# STONEBRIDGE METROPOLITAN DISTRICT NOS. 1-6 DISTRICT BOUNDARIES

# V\_1 District Boundary Map comments review 1.pdf Markup Summary

STONEBRIDGE METROPOLITAN DISTRICT NOS. 1-6 DISTRICT BOUNDARIES

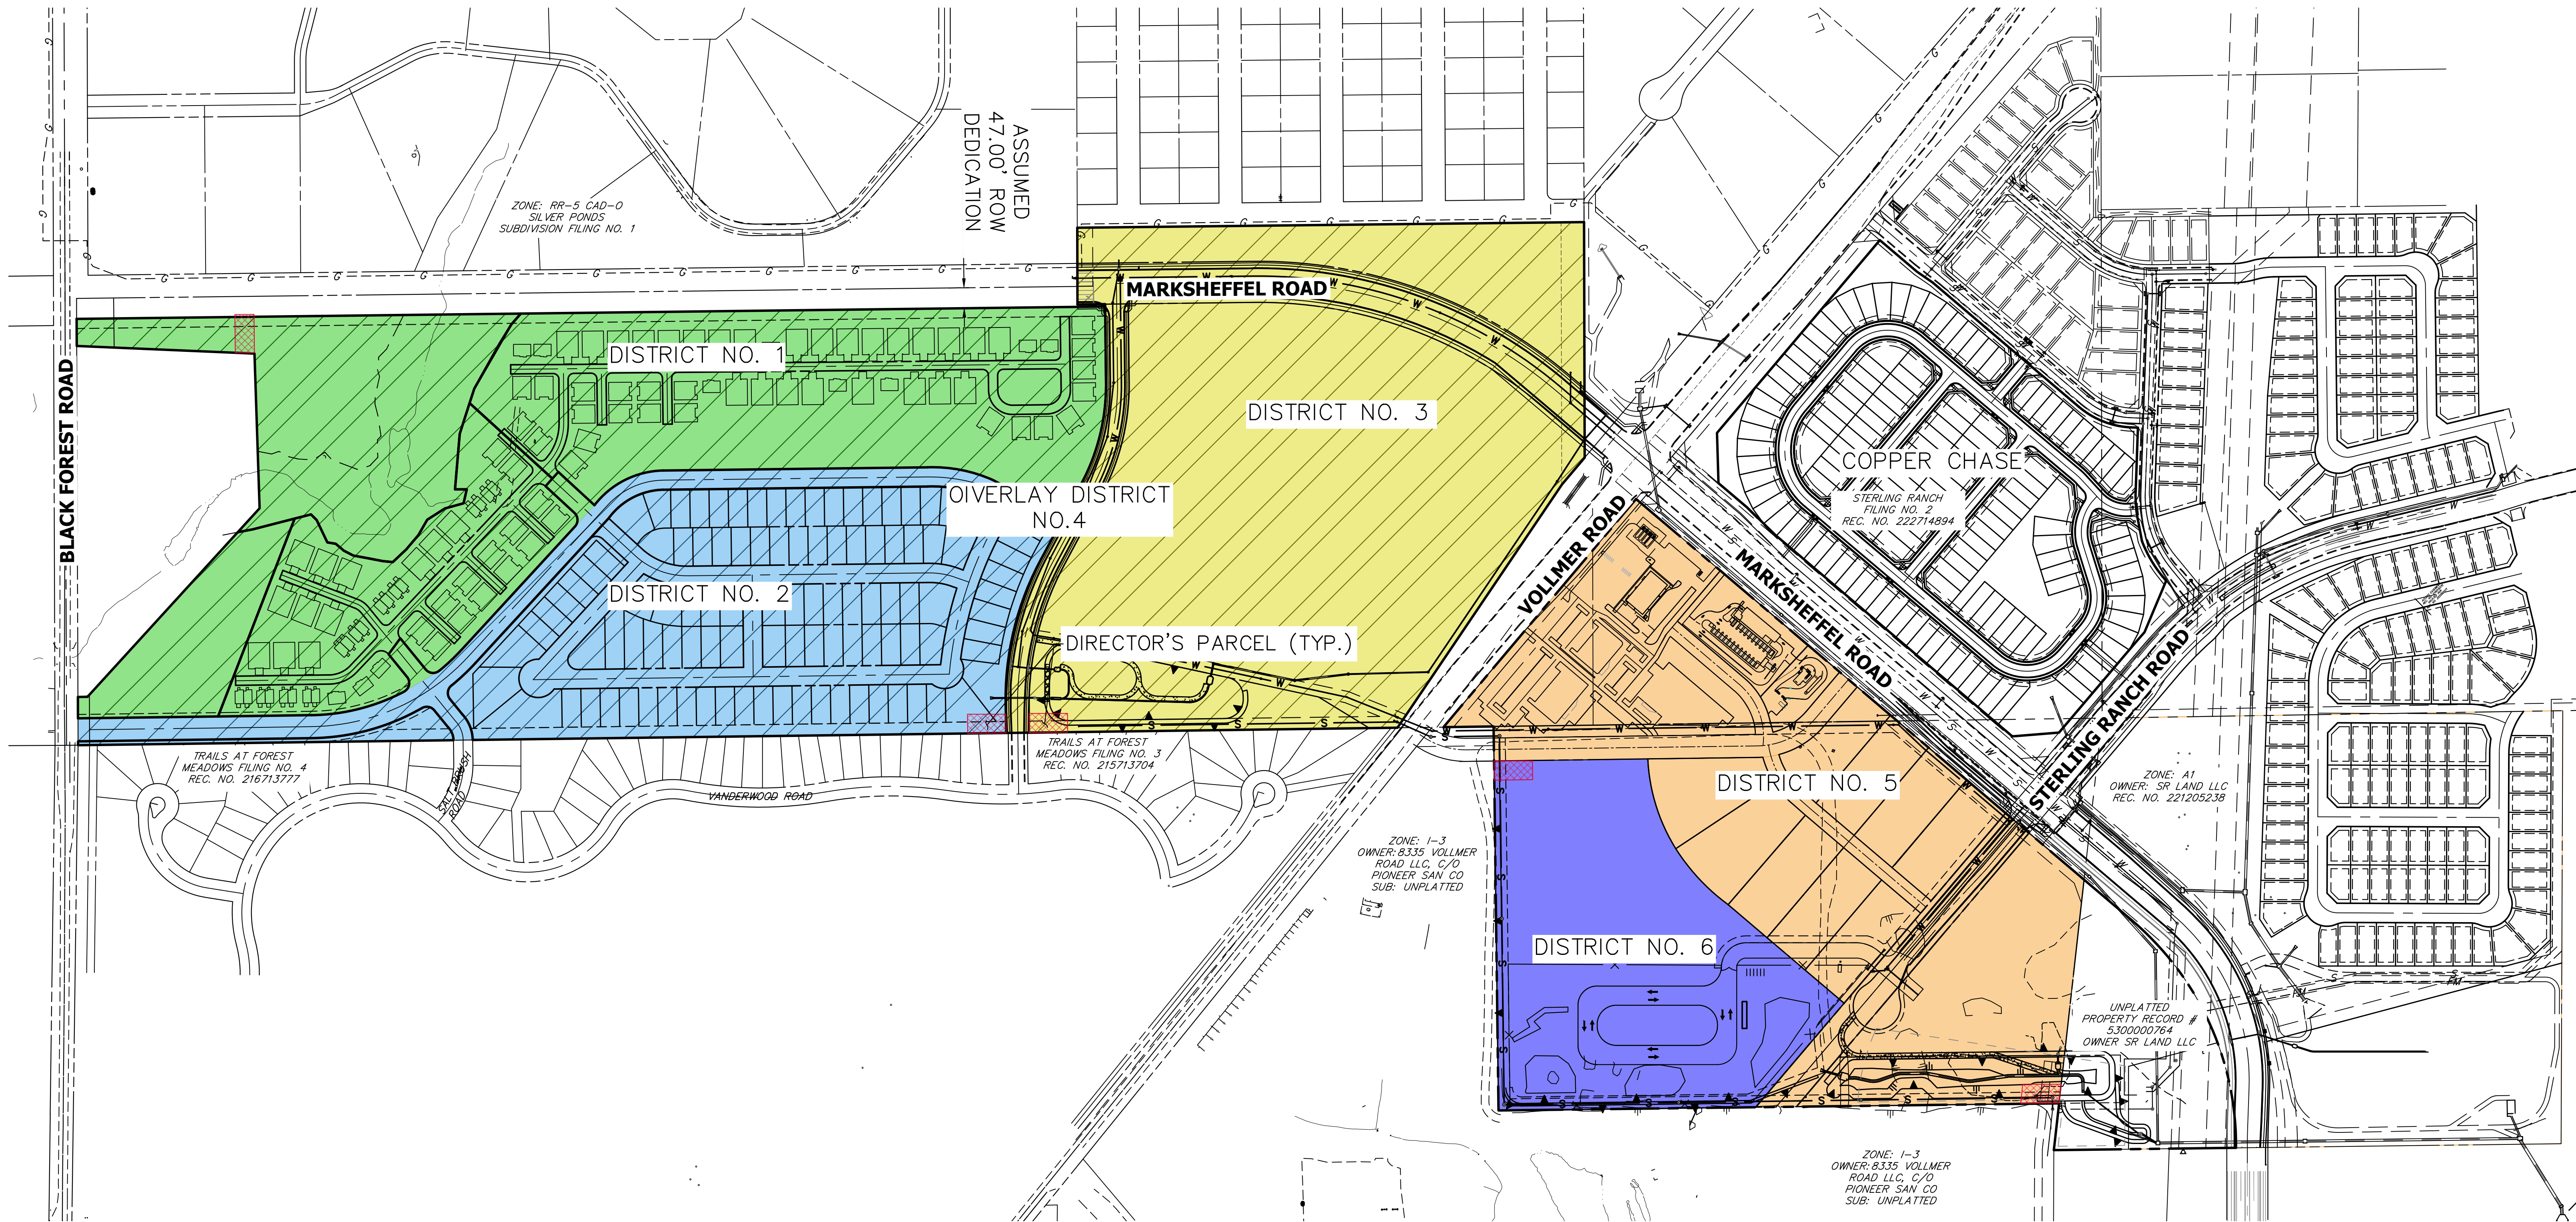
Should this be included in D2 or D1; Marksheffel will be built by developer and remnant piece north of Marksheffel is not sold to apartments, but retained by Developer; should the multifamily be in one district? .

There is a detention tract at bottom of D3 that will be constructed by developer w D1 and D2 development; should this be in another district?

The BOCC has frowned upon the developer retaining control after development is built out- you are Proposing Director parcels which are not a part of model service plans....address rational and purpose in Letter of intent (LOI)
